Planning Inspectorate

Our Ref: EN010162

Application by Elements Green Trent Limited for an order granting development consent for the Great North Road Solar and Biodiversity Park

Advice following issue of decision to accept the application for examination

0 20 40 80 120 160 Metres

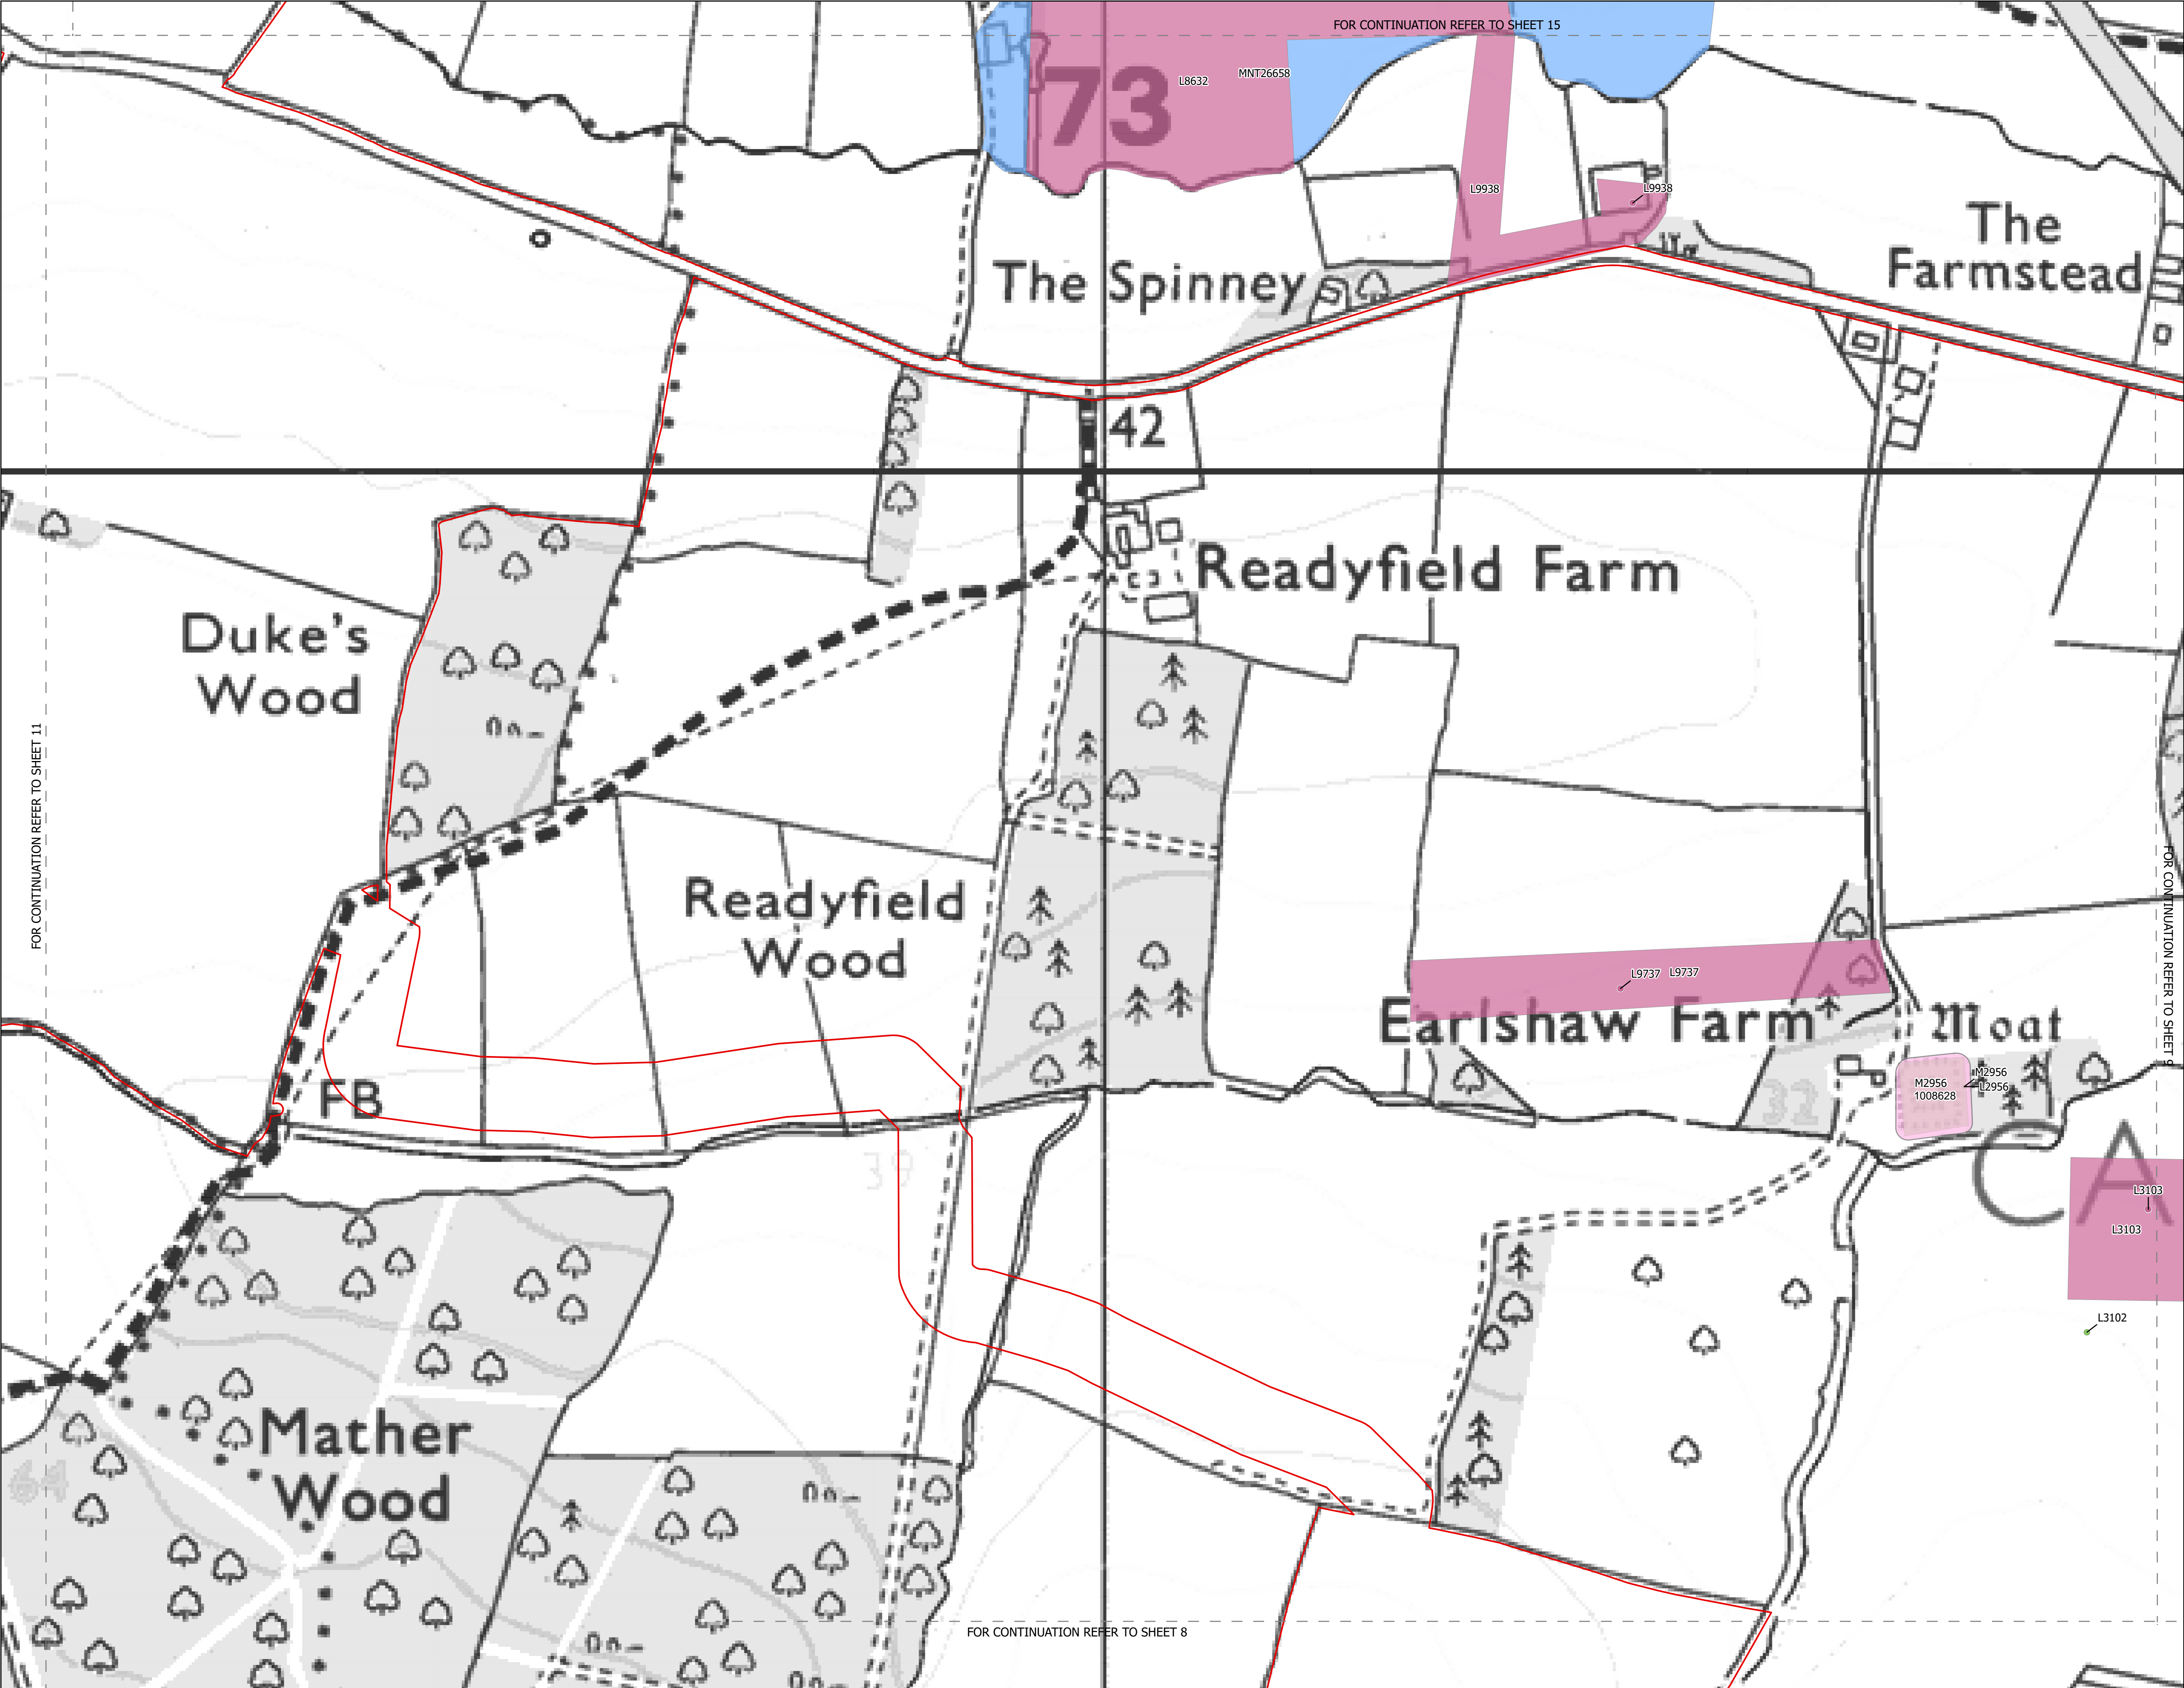
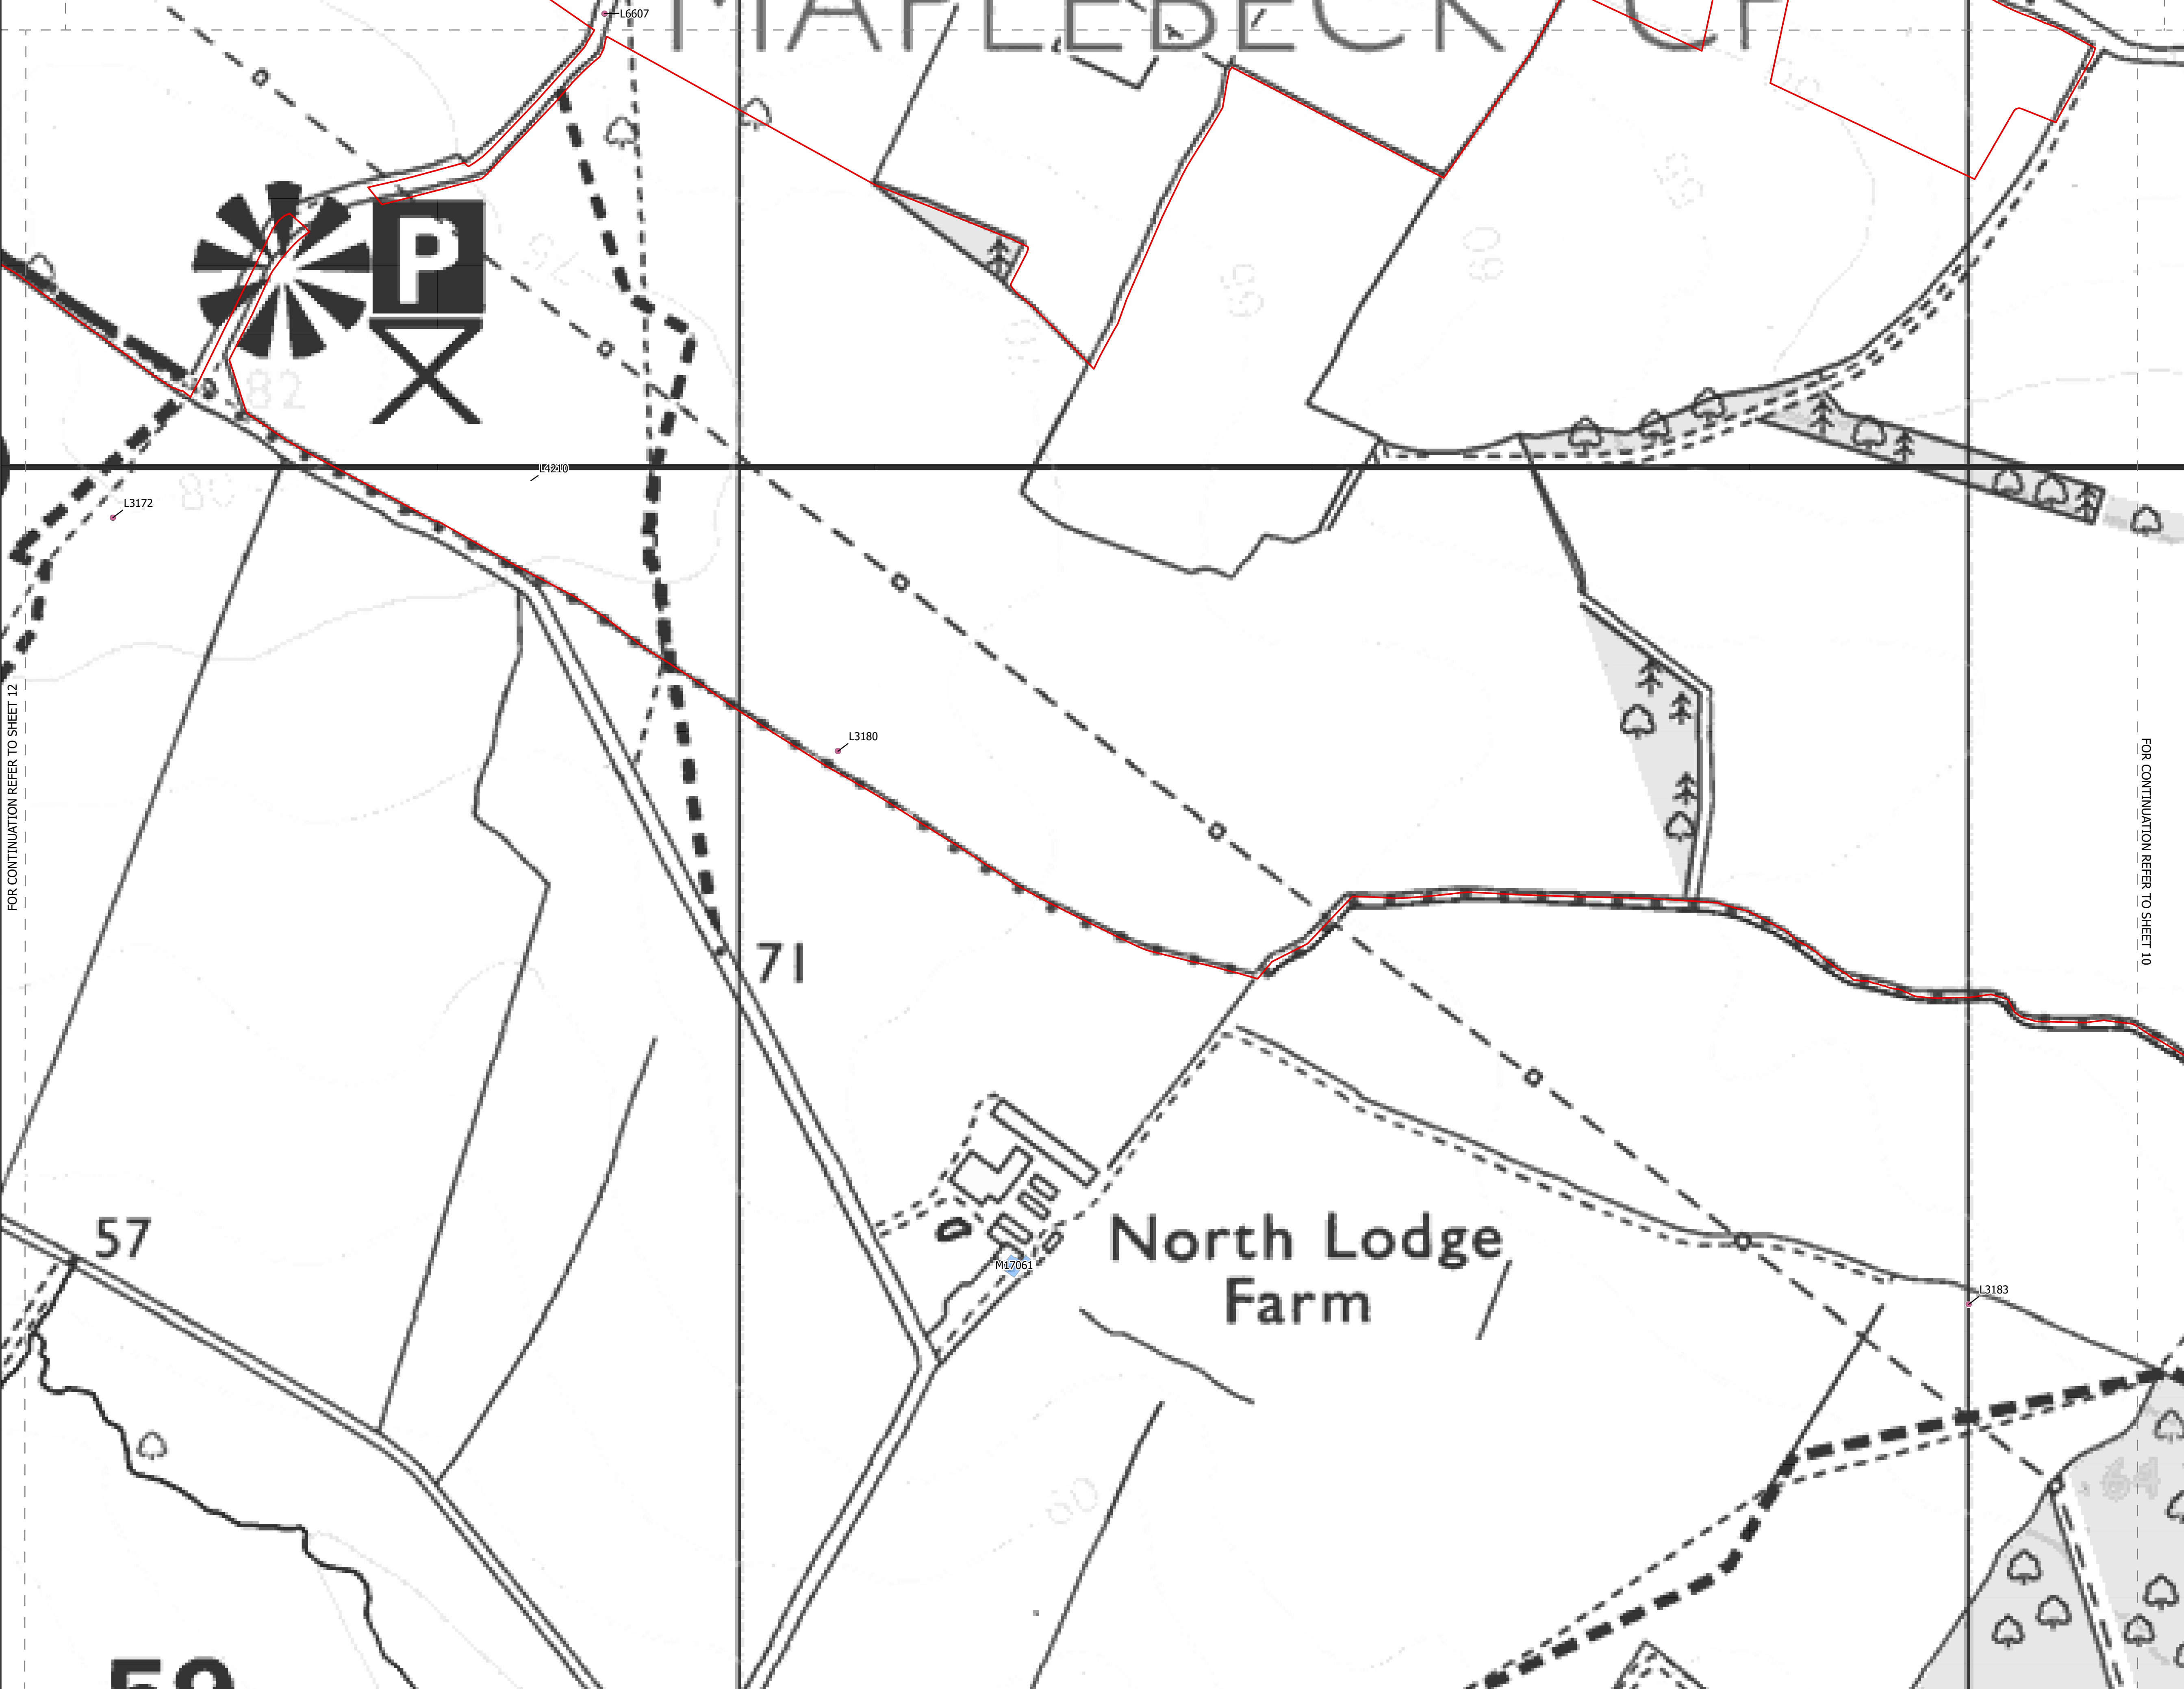
Statutory and non-statutory features of Historic Environment Plan (Doc 2.17)

The applicant is advised to review these figures for clarity, specifically relating to the following points:

- due to the scale of the icons used and similar colouring, it is difficult to differentiate between Historic Environment Record (HER) assets and listed buildings/ grades
- a very similar colouring scheme between HER recorded 'undated' period and scheduled monuments keys has been used
- due to the small scale of the icons, the labelling sometimes obscures the record being shown.

Plate A9.2.1: WFD Waterbodies in proximity to the Order Limits – Cycle 3 2022

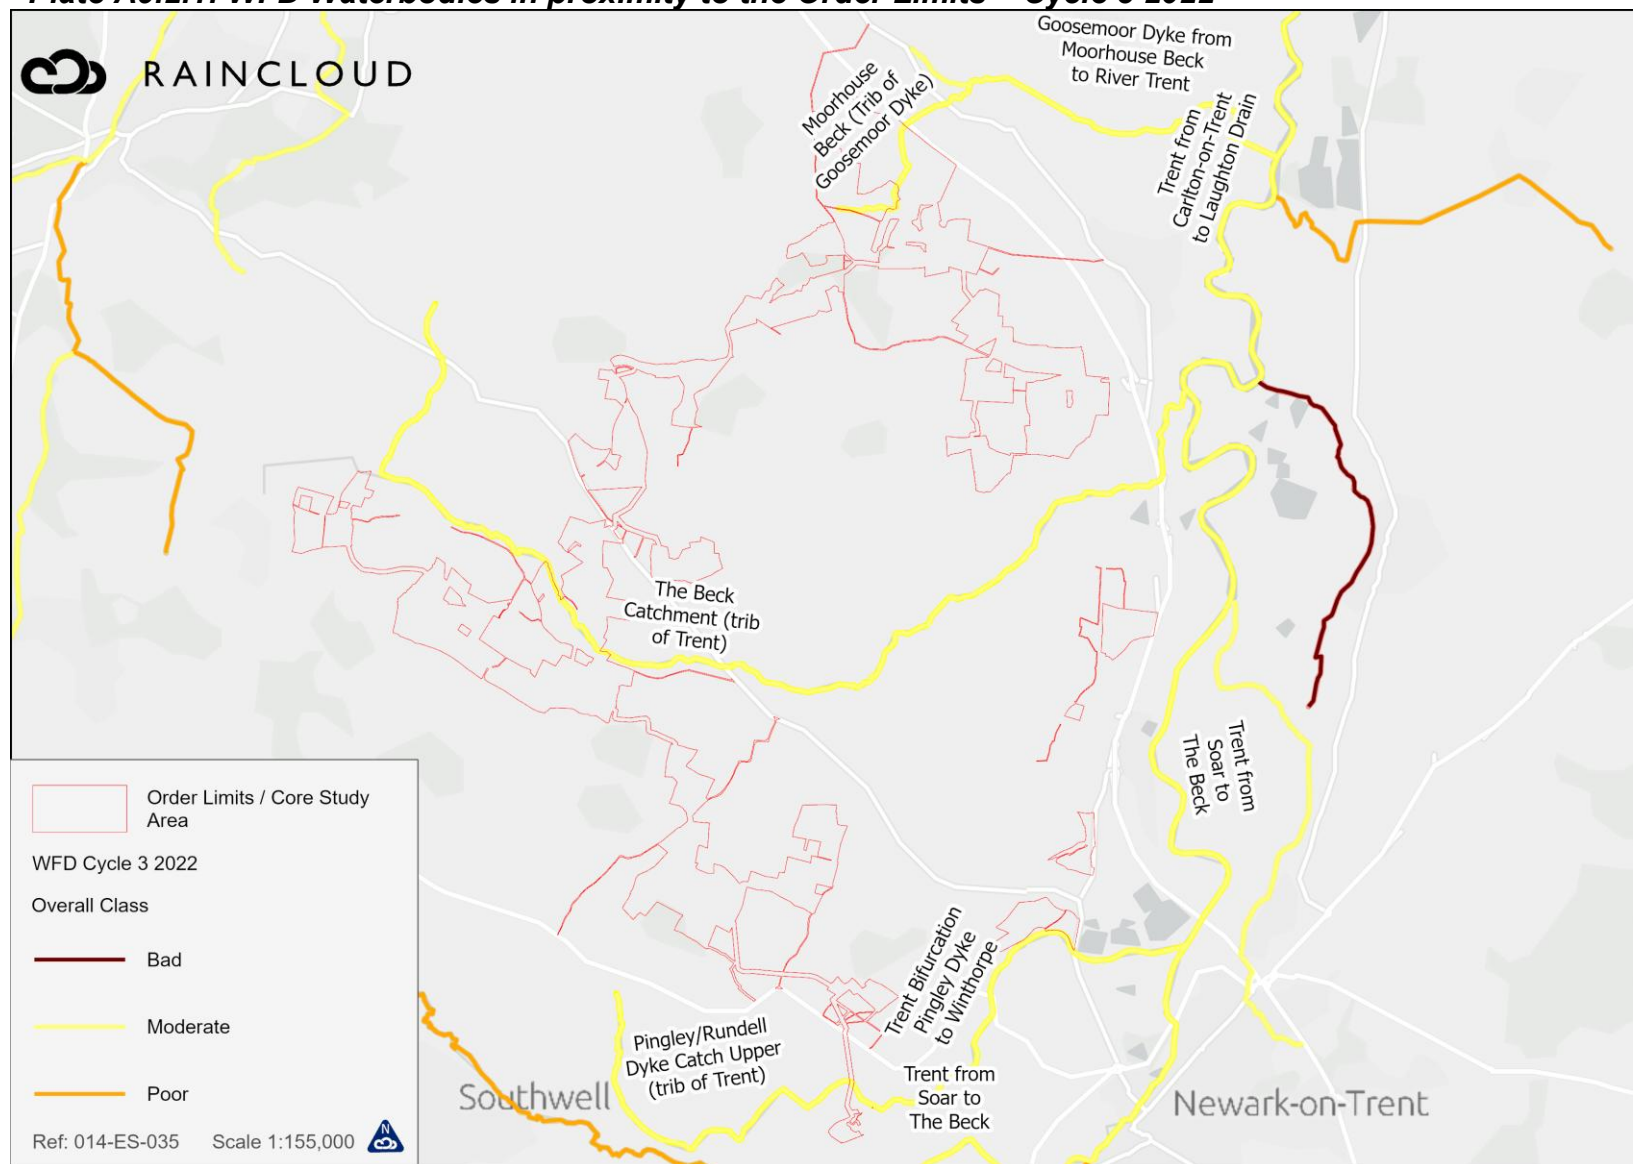
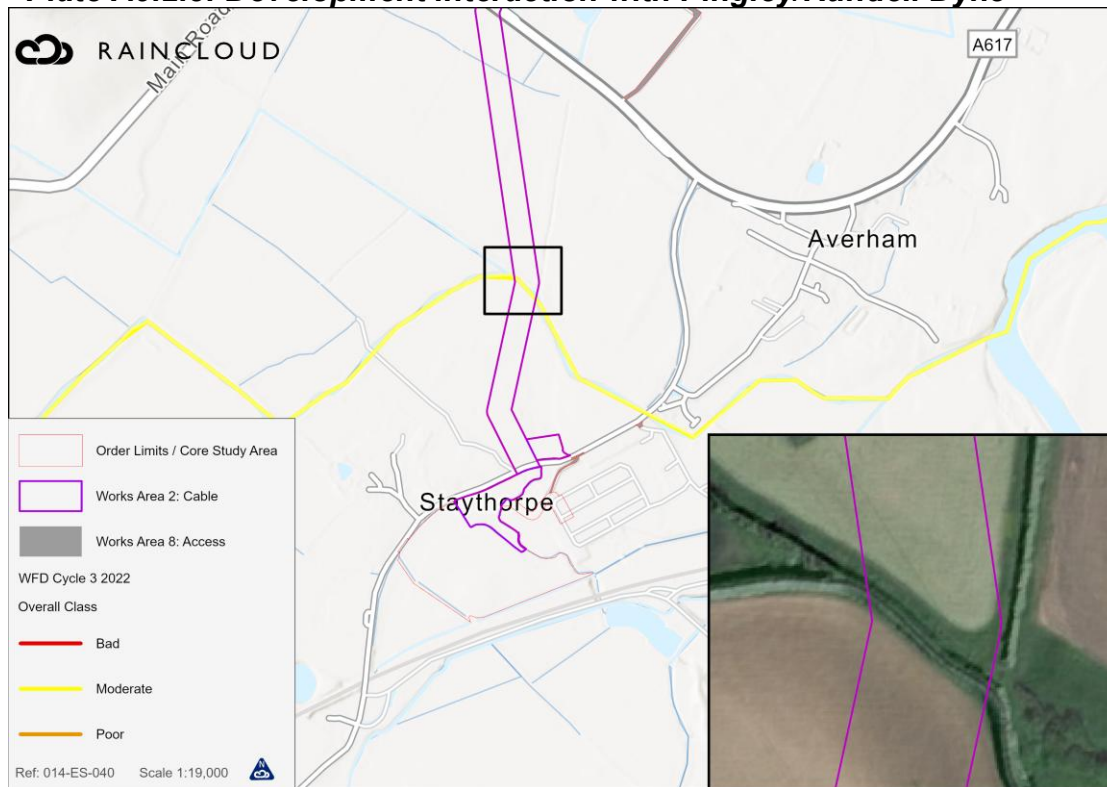
Water Bodies in a River Basin Management Plan (Doc 2.6), Environmental Statement figure 9.4 (Doc 6.3.9.4), ES figure 9.6 (Doc 6.3.9.6), Figures within the Flood Risk Assessment (Doc 6.4.9.1) and Water Framework Directive Assessment (Doc 6.4.9.2)

The applicant is advised to review these figures for clarity and consistency. The figures present varying levels of detail, geographic extent and sub sections/ catchments, waterbody naming and waterbody routes. The Inspectorate advises that the figures should show a consistent presentation of data. The figures should also show, where relevant, the extent of main rivers and ordinary watercourses.
